**RE: Application by Port of Tilbury London Limited for an Order Granting Development Consent for a Proposed Port Terminal at the Former Tilbury Power Station ('Tilbury2')**

Buglife maintains its previous positions outlined in the comments dated 16<sup>th</sup> March 2018, but would like to submit further comments to clarify its position in response to the Tilbury 2 Document Ref PoTLL/T2/EX/60 document, titled 'Response to the written representations, local impact reports and interested parties' responses to first written questions'.

LOCAL WILDLIFE SITES.
THURROCK DISTRICT
Th39. Lytag Brownfield

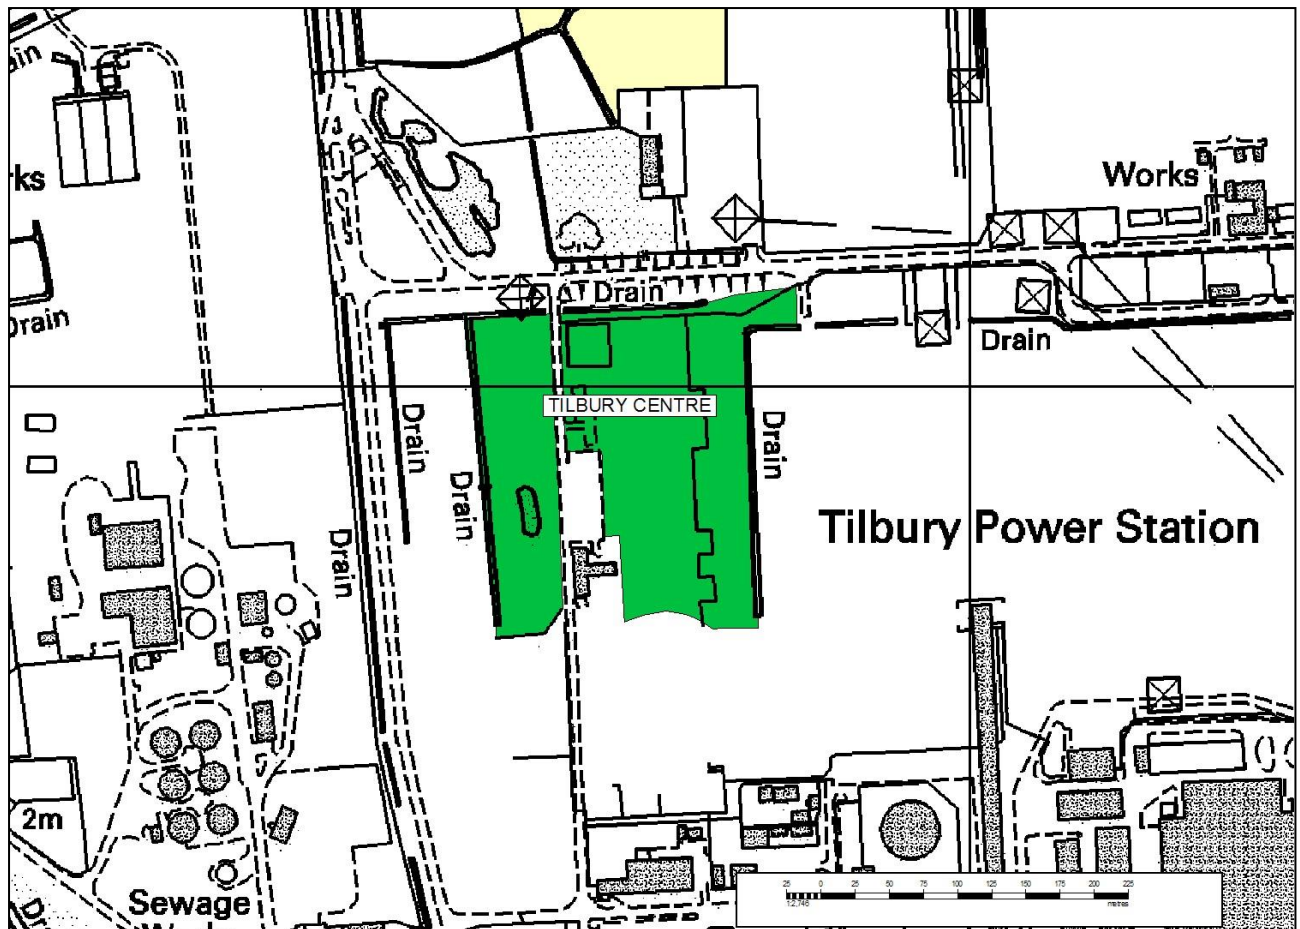
of the site need to be considered within the overall importance of the site, not merely the Lytag Local Wildlife Site (LoWS). This view is supported by Thurrock Council's recent Local Wildlife Site review which extends the LoWS and renames it the Tilbury Power Station LoWS, as addressed during the April 'Issue Specific Hearing on Planning Policy and Environmental Matters'. As the applicants own commissioned surveys by Mark Telfer state, "The Infrastructure Corridor itself is of middle-ranking importance compared to the other sub-sites but still probably of national importance in its own right." Buglife suggests that this should form the "evidential basis" which the applicant suggests is missing from Buglife's claim that the infrastructure corridor should also be considered as important. The value of the entire site is reflected here, as even the "middle-ranking" sub-site is considered of national importance in its own right, let alone when considering its value in concert with the other survey compartments.

- Steve Plumb, representing Thurrock Council, indicated that the recent review of Thurrock's Local Wildlife Sites had resulted in the LoWS being enlarged from the Lytag portion of the site to a greater extent, leading to its change in name to Tilbury Power Station LoWS. Buglife were unaware of this as the ES fails to acknowledge this throughout. This independent assessment supports

Buglife's consistent stance that the site as a whole be considered as a single large unit rather than individual compartments and that the site's interest goes beyond the Lytag area itself but the wider mosaic of habitats supported at Tilbury Power Station.
